Norfolk Boreas Offshore Wind Farm Applicant's Comments on Deadline 14 Submissions

Applicant: Norfolk Boreas Limited
Document Reference: ExA.ASR-D14.D15.5.V1

Date: 08 September 2020
Revision: Version 1
Author: Royal HaskoningDHV

13 APPENDIX 6 SCHEME OF HIGHWAY MITIGATION (B1145, CAWSTON)

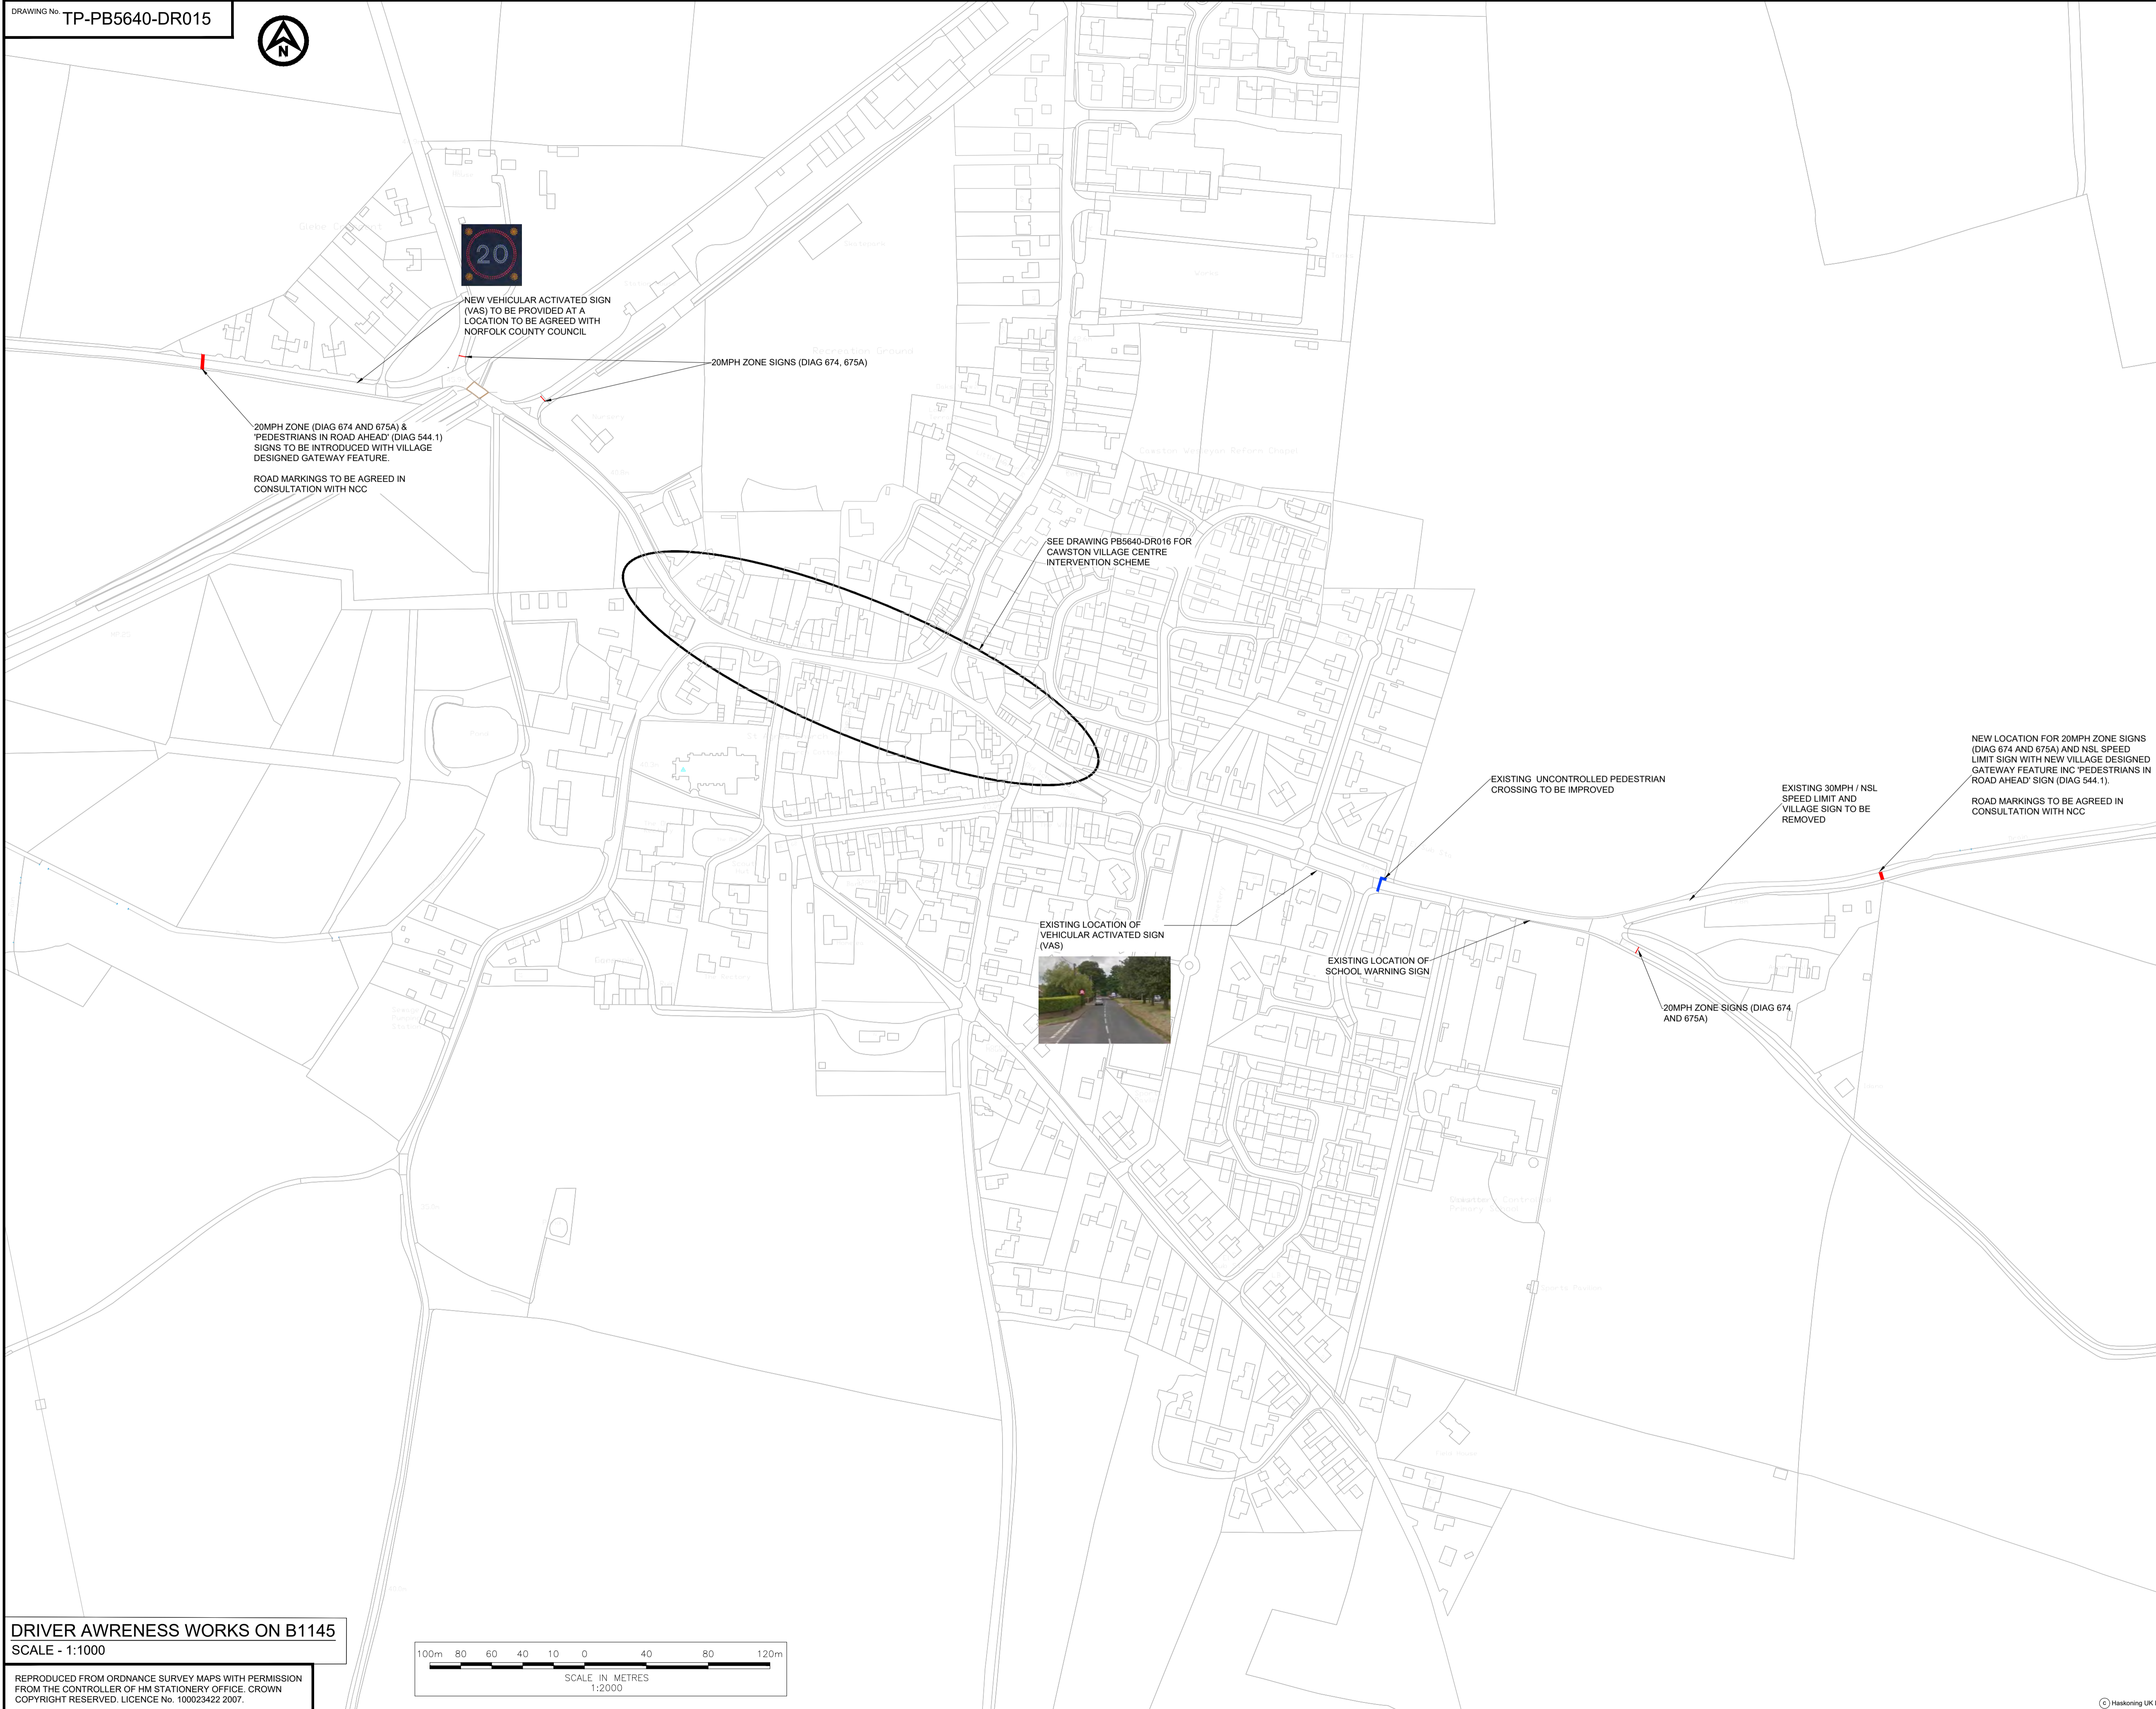
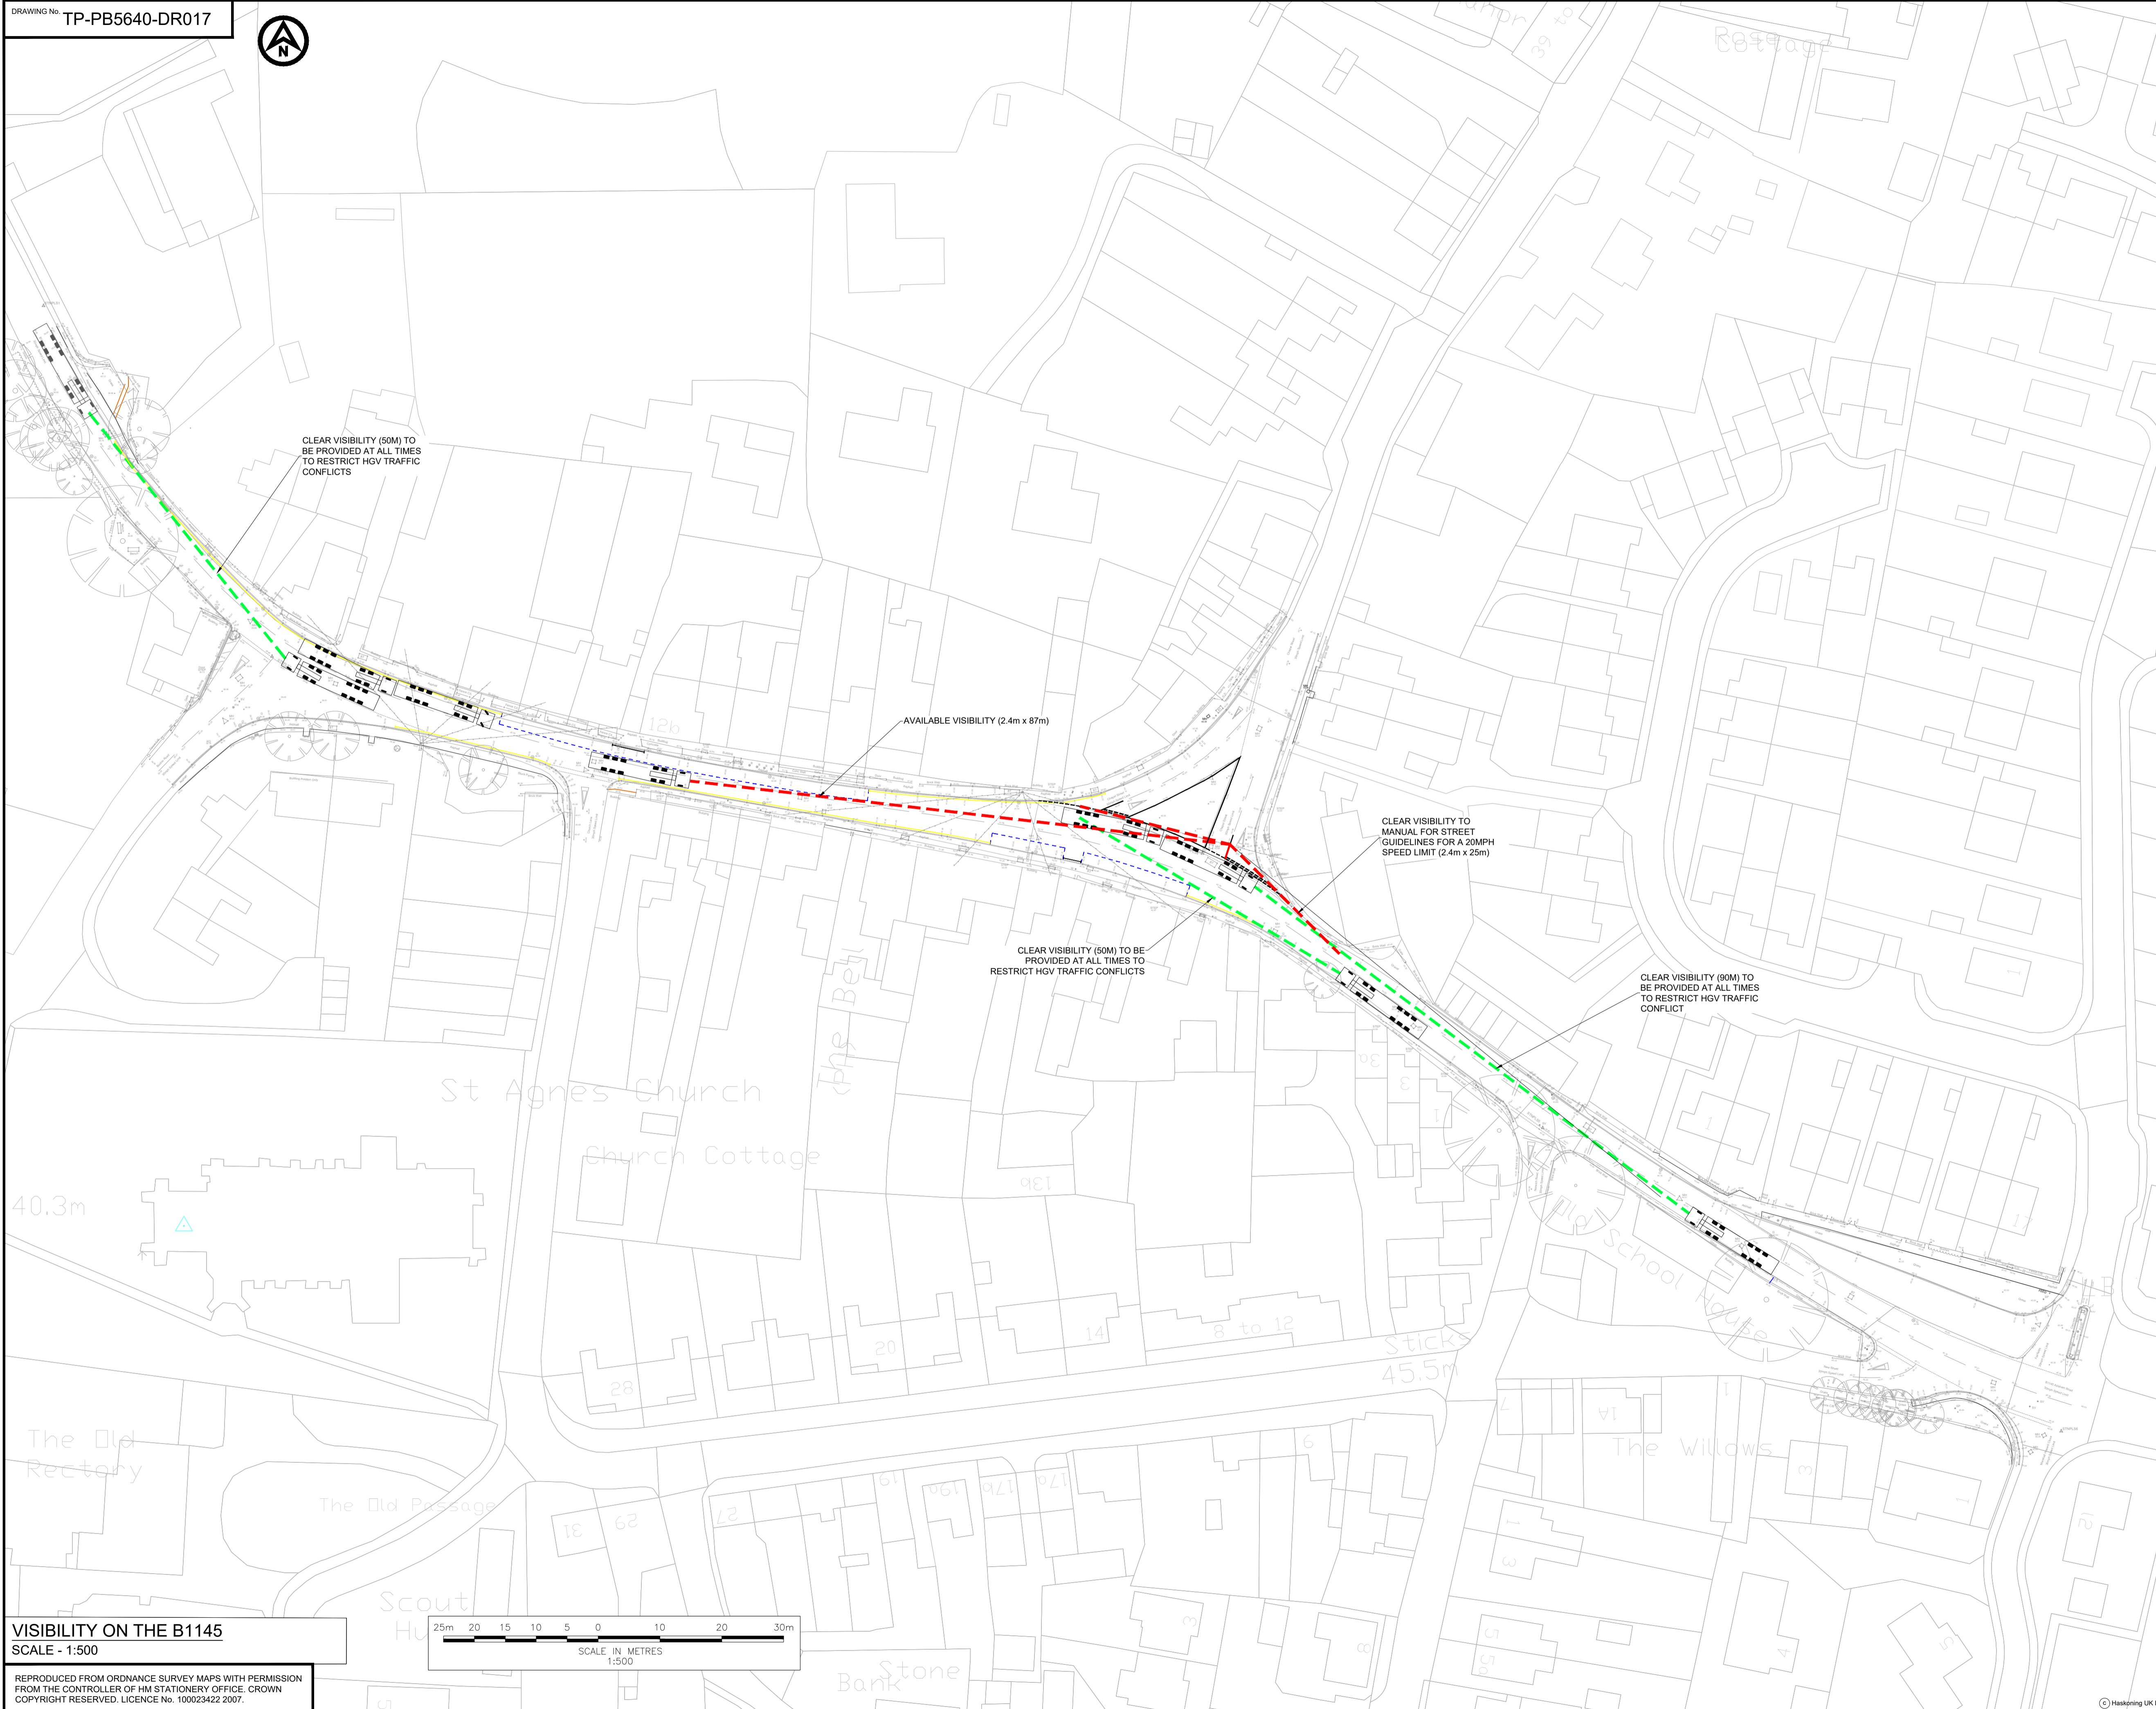
Plans at 1:500 are difficult to view and cannot be accurately scaled without the CAD package that they are drafted on. Marked visibility lines here pass over parking bays and skim wall/ pavement edges, indicating clear visibility distances that cannot be accomplished without eliminating all other traffic or parking. The scheme relies heavily on a sequence of vehicles waiting for opposing ones in a known pattern. Driver compliance may make this a possibility for the HGV drivers but you are proposing this for a village which already has a difficult road because of width and bends. There is everyday traffic in this scenario and they will not

The realignment offers visibility for the yielded vehicles to see one another but does not take into consideration vehicles from my driveway, Chapel Street and Norwich Road, the visibility for all of us will be questionable adequate and we in fact become those highway hazards. I request all involved look at the scheme with a view of not just getting the HGVs through but the risks and impacts on other drivers/ vehicles attempting to join this traffic “flow”.

Technical Note Entrance and Egress onto the B1145, [REP14- 044, Drawing TP-PB5640-DR066] illustrates a westbound HGV traversing tight to the kerb (a layer that for consistency was lifted from drawings previously submitted to the examination and now contained in the OTMP Appendix 6 [REP14-024]) The layer was created to enable the design team to determine ‘pinch points’ and mitigate accordingly. Having established there is a pinch point outside of White House Farm, the design proceeded to create a yield point and ensure there is adequate visibility for all road users to react to the changes in the highway geometry to avoid vehicle to vehicle conflicts. The introduction of the yield point, will ensure that the path taken by the bus illustrated in Technical Note Entrance and Egress onto the B1145 [REP14-044, Drawing TP-PB5640-67] (which avoids pedestrian conflict) is more likely as there will not be an opposing traffic stream.

OTMP Appendix 6 [REP14-024] illustrates that an eastbound yielding HGV has a total forward visibility of 90m up High Street/ Aylsham Road, which is more than adequate to yield at an appropriate point.

The drawings have been informed by topographical surveys, critical measurements and numerous site visits and observations and are considered an accurate reproduction of baseline and HIS environments.
